Subject: Re: Objection - 2023/62/92966/E rear of Cliffe Lane

Objection - 2023/62/92966/E rear of Cliffe Lane

HOUSE TYPE A2_3 STOREY SPLIT
SEMI_2BED_4PERSON = PLOT 70

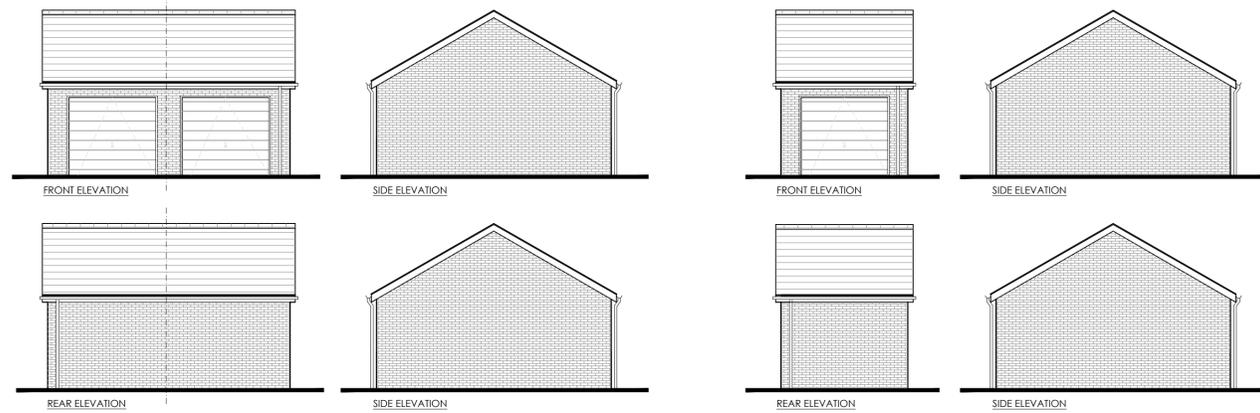
The applicant responses on Green Belt and Scale of the Development are in contradiction with the plans, as the plans show three storey on the boundary.

Should this development be allowed to go ahead, the removal of 3 storey properties must be considered as it will be have a negative visual impact and not be in keeping with the properties around this area. The three storey , if not removed, at the very least need to be lower down within the development to have the least impact on the landscape and in accordance with their response.
